Your Ref: OWPC24421
Our Ref: LU/273/19/HH 28-08-2019
Please ask for:
Zac Denton

Single storey rear extension and single storey extension to rear of existing garage.
Windlesham 7 St Winefrides Road Littlehampton

Drawing Title: Proposed Plans, Elevations and Site Block Plan		
Drawing Number: 1214.02.a		
Scale: As stated printed @ A1		
Date: 09/08/2019

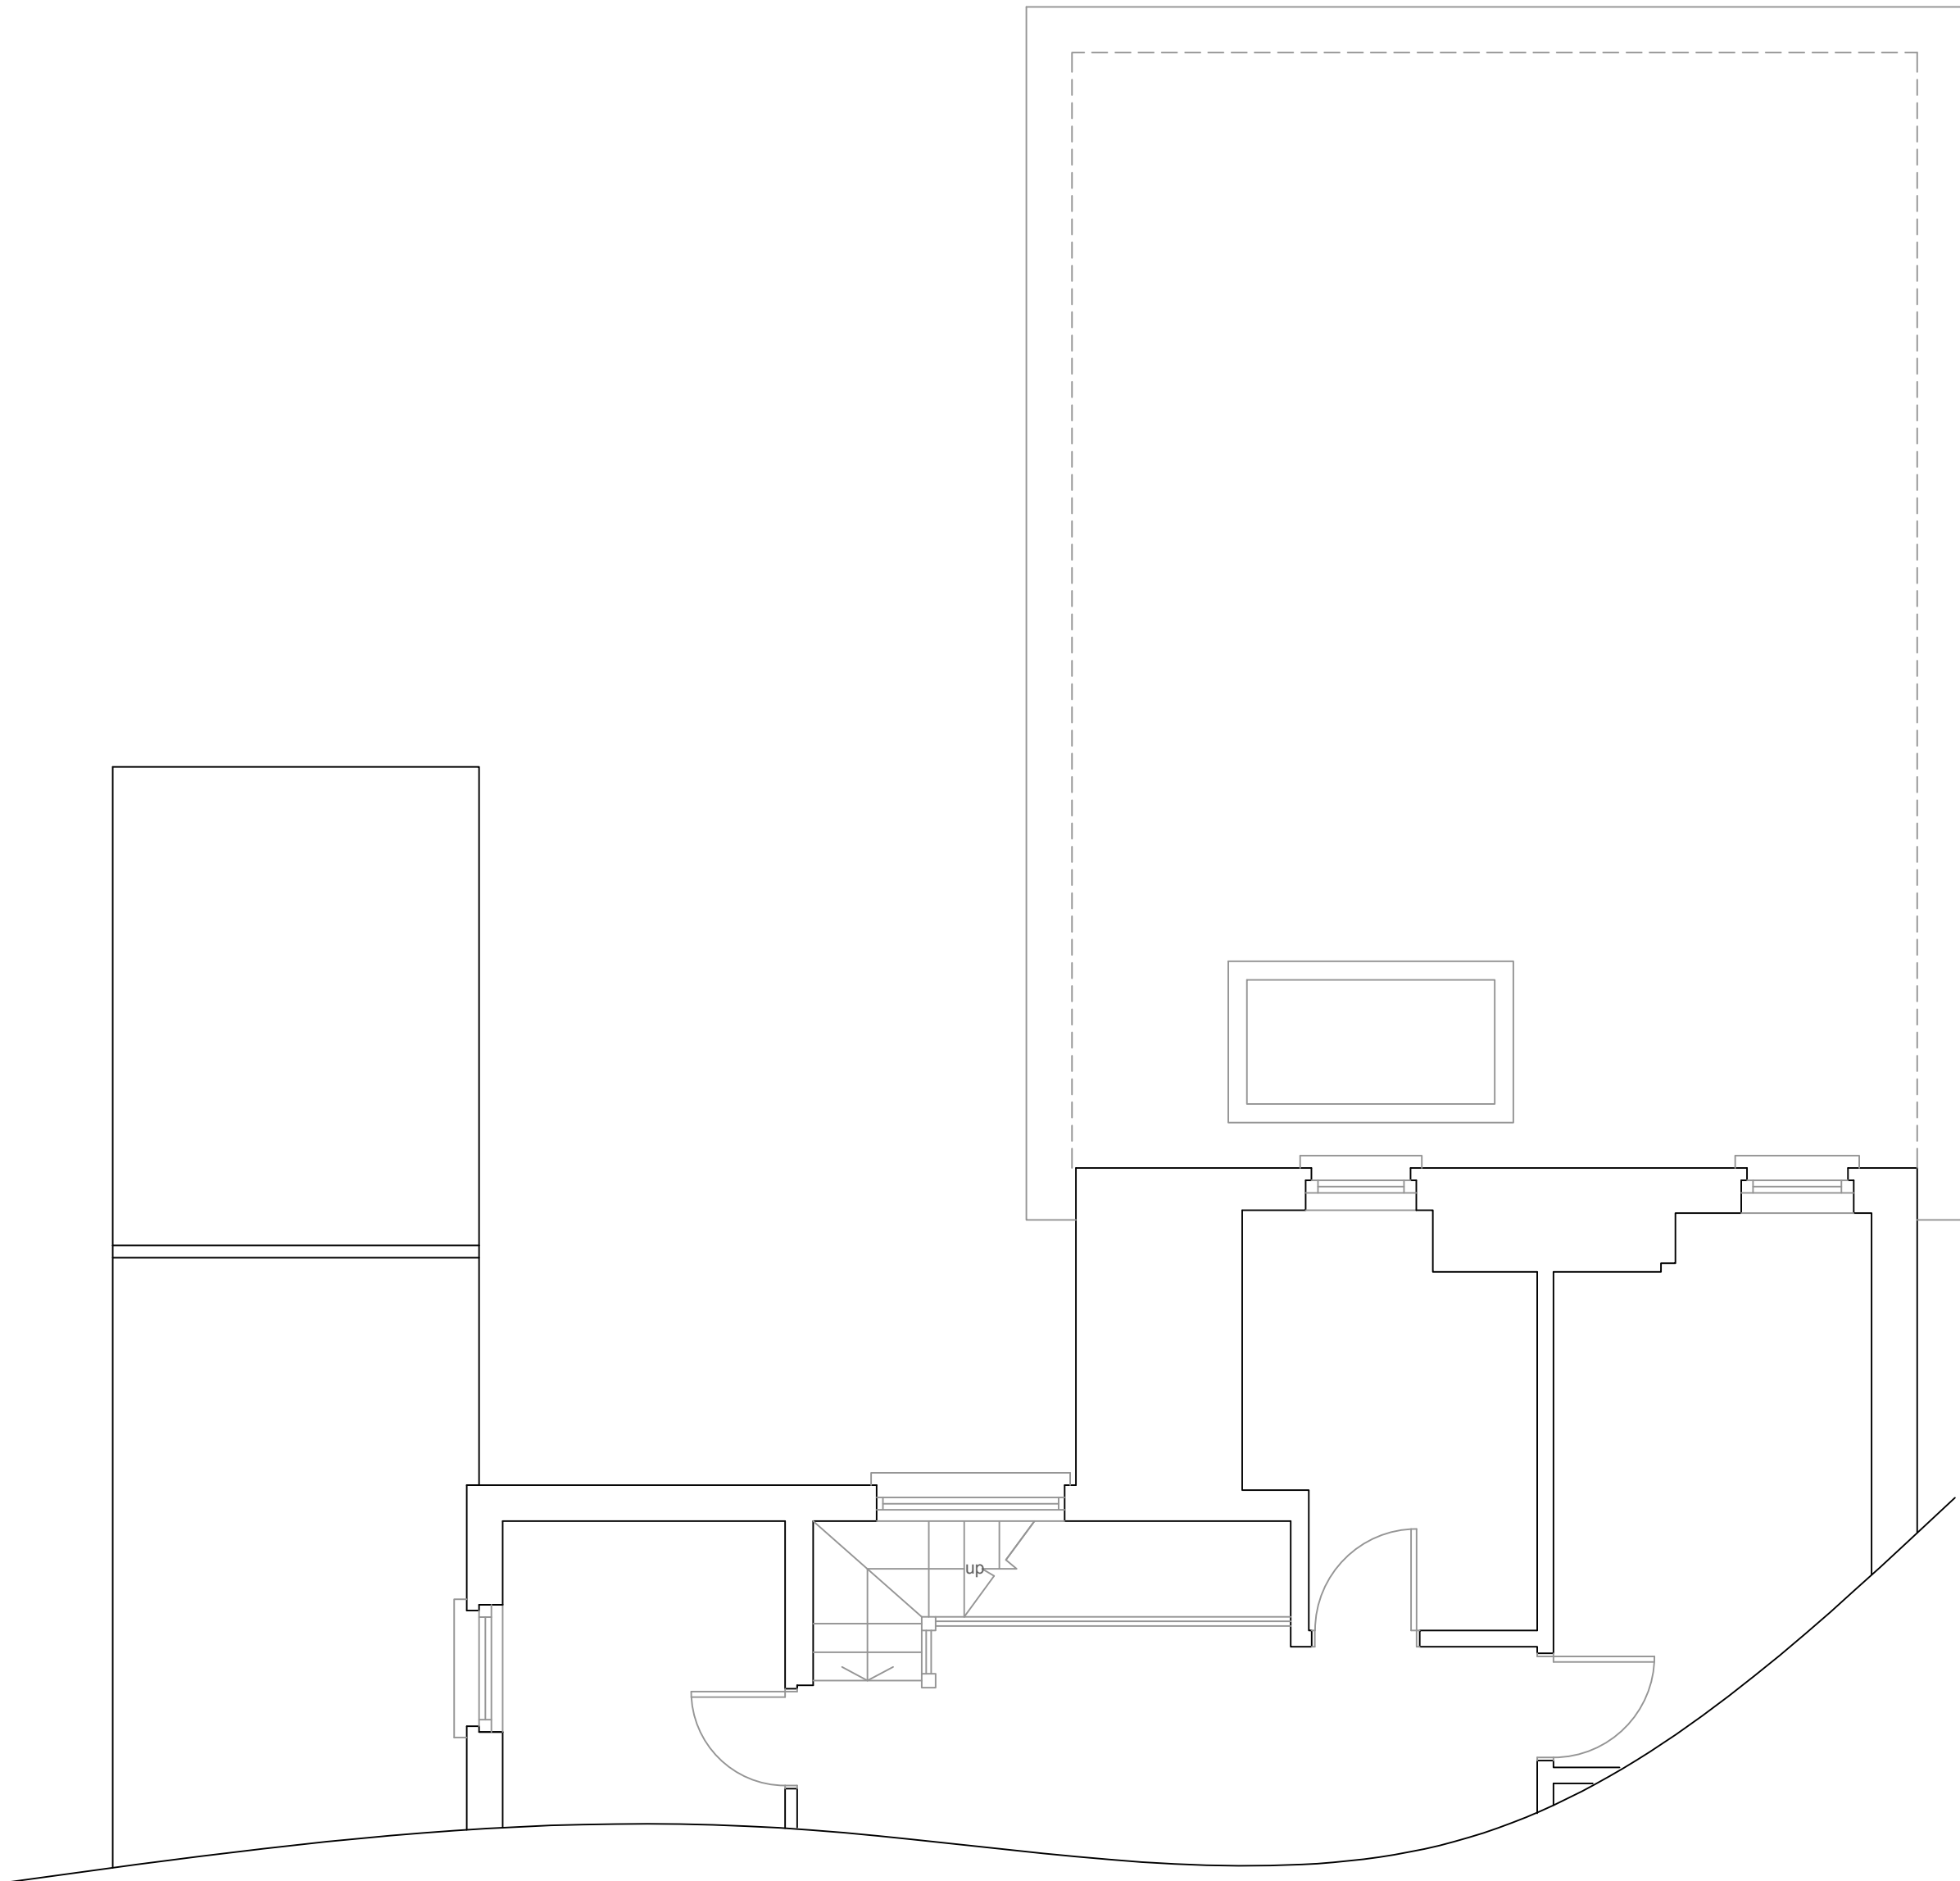
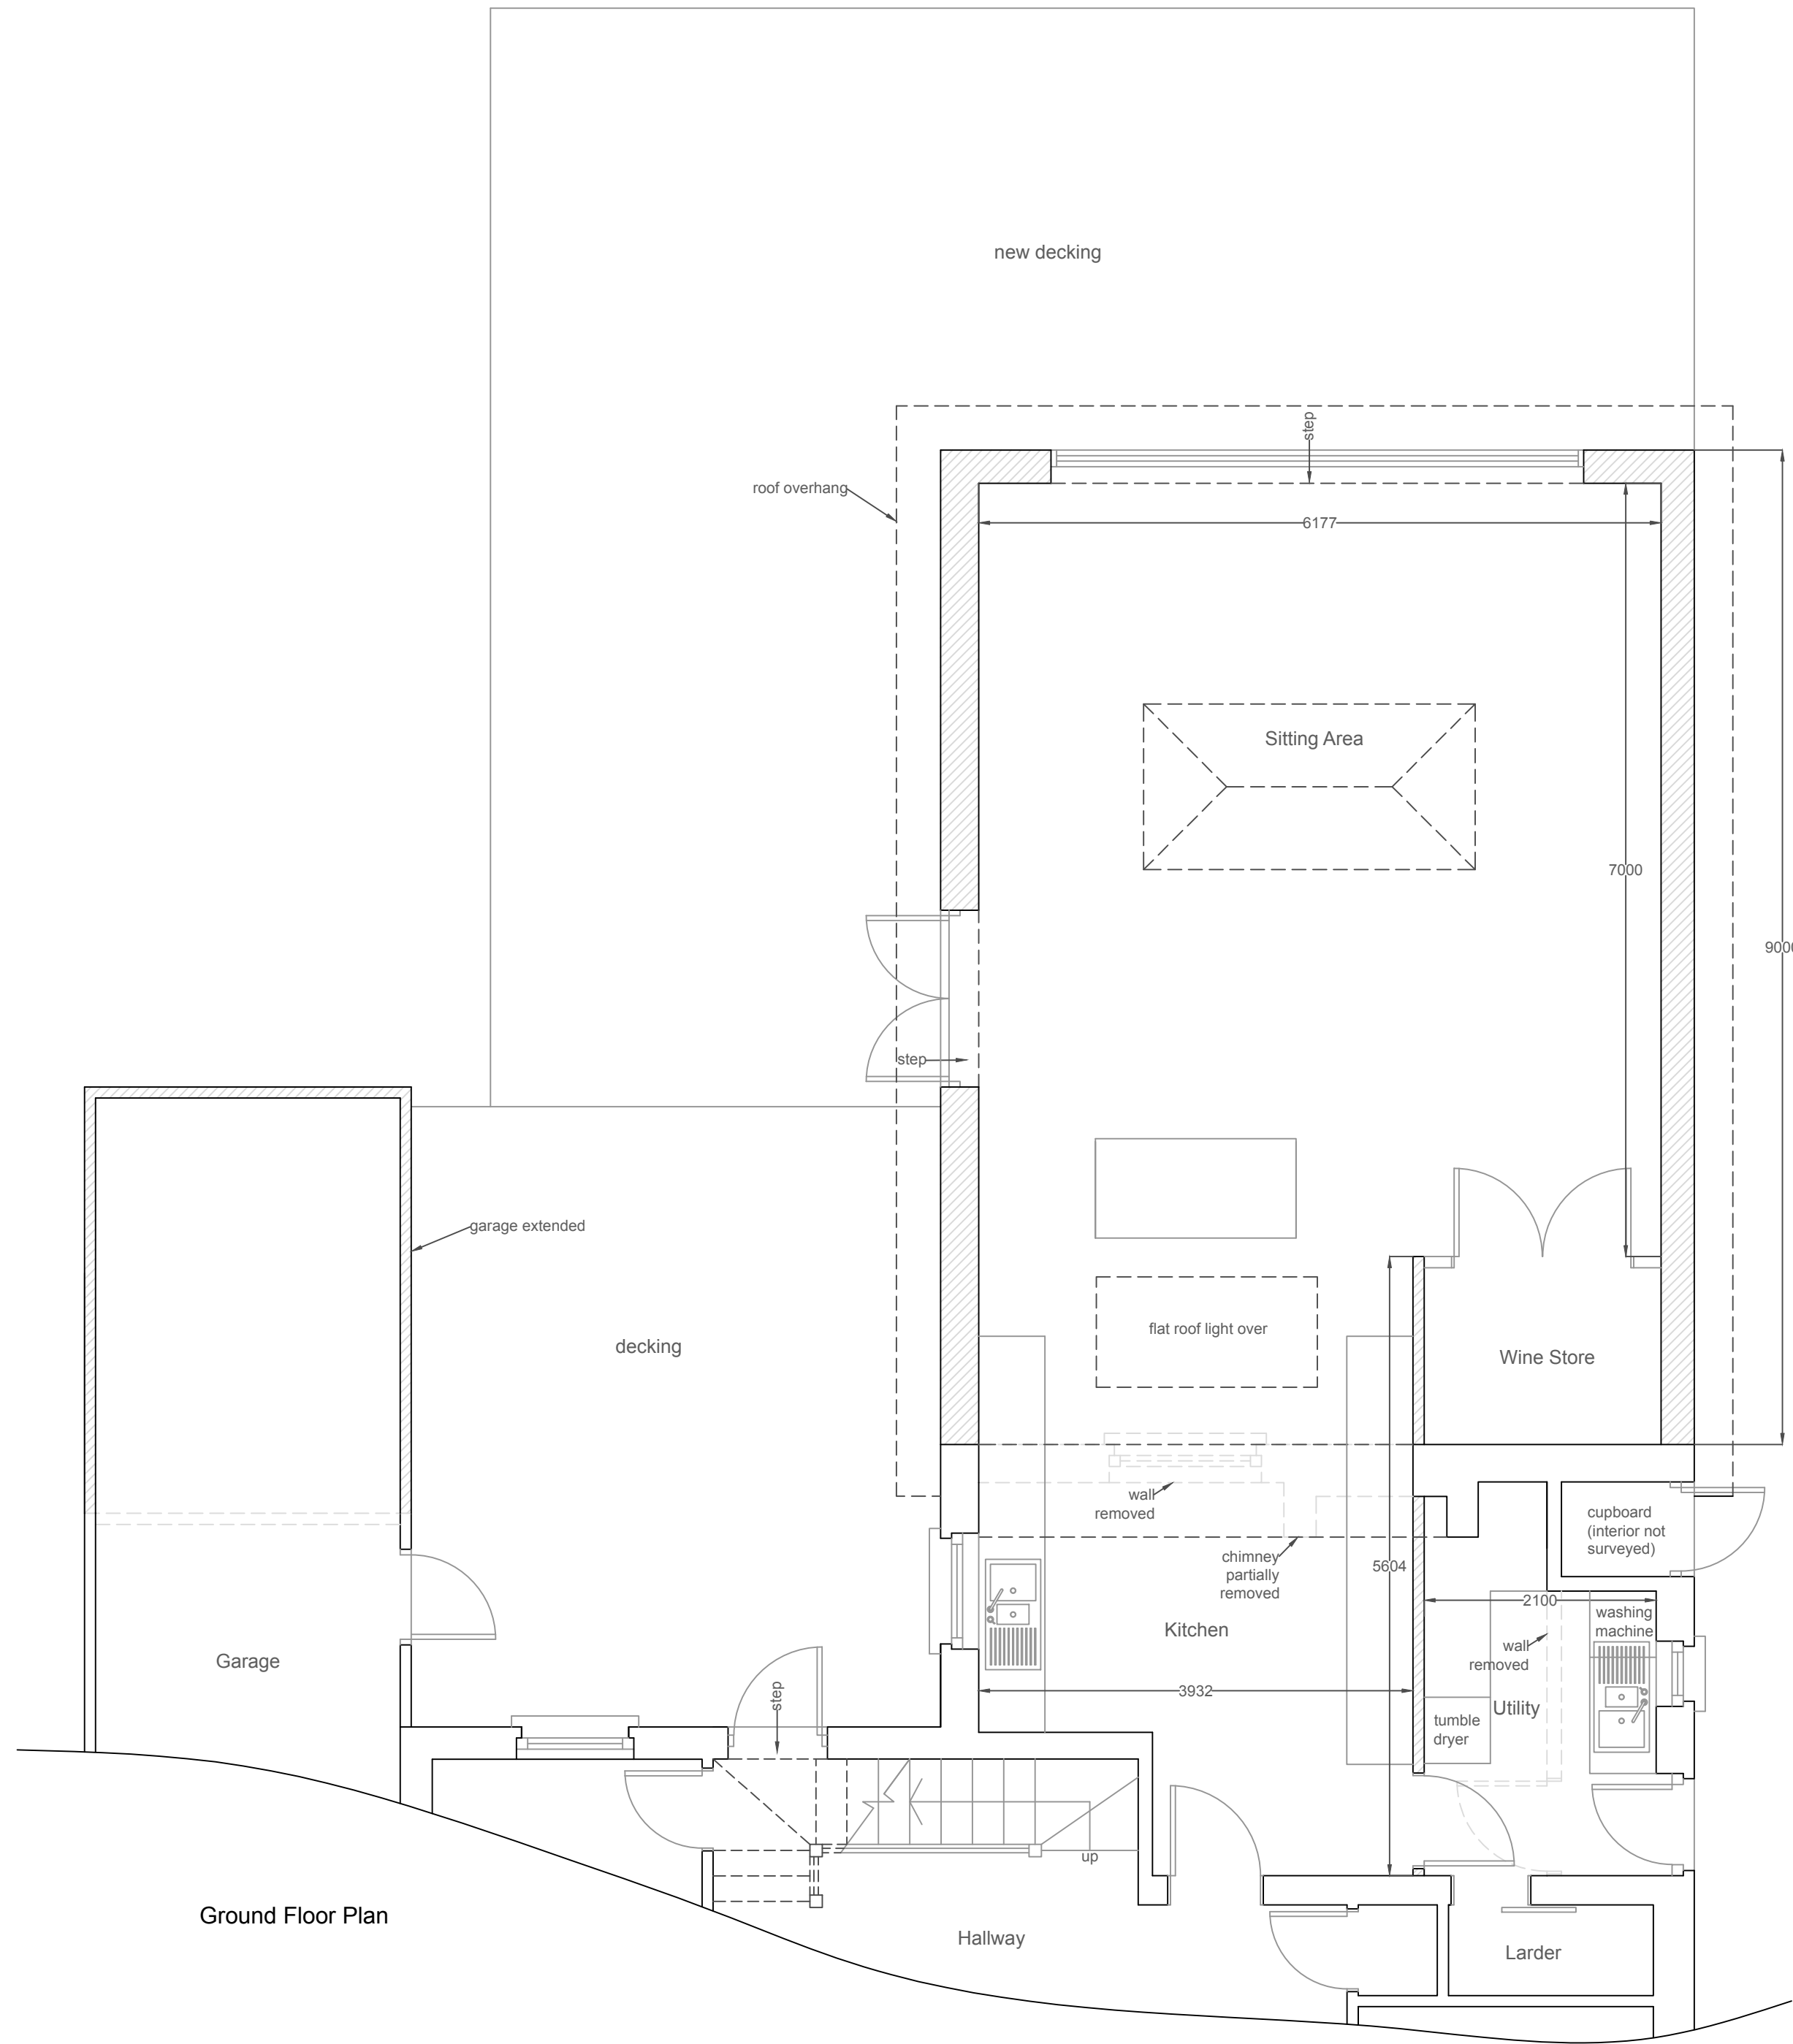
With regard to the planning application at the above property, as direct neighbours, we have some points that we would like to be considered.
We refer to the single storey extension on the north side. We were forewarned of a possible application and consider this proposed design to be a very large footprint. We wish to oppose this application for the following reasons.
The height (approaching 3.5m) of this building will cause shadow to our garden and loss of light to the rear of our property, except when the sun is at its highest point.
The length of the extension (9m) means that there will be a brick wall for almost half the length of our garden. The length is far beyond the building line of our garage.
The height and length together, mean that we will be looking at a large brick wall. This will be difficult to screen due to the height.
The far end of the extension will be affected by/affect the roots of the mature beech tree near to the fence on our side.

As this extension has a flat roof, it will not give an attractive outlook from the kitchen and upstairs of our property. Many mature small trees shrubs will be lost.
We hope you will take these points for discussion about the above application and we invite you to visit, to look at the proposed site to see it from the angle of our property.
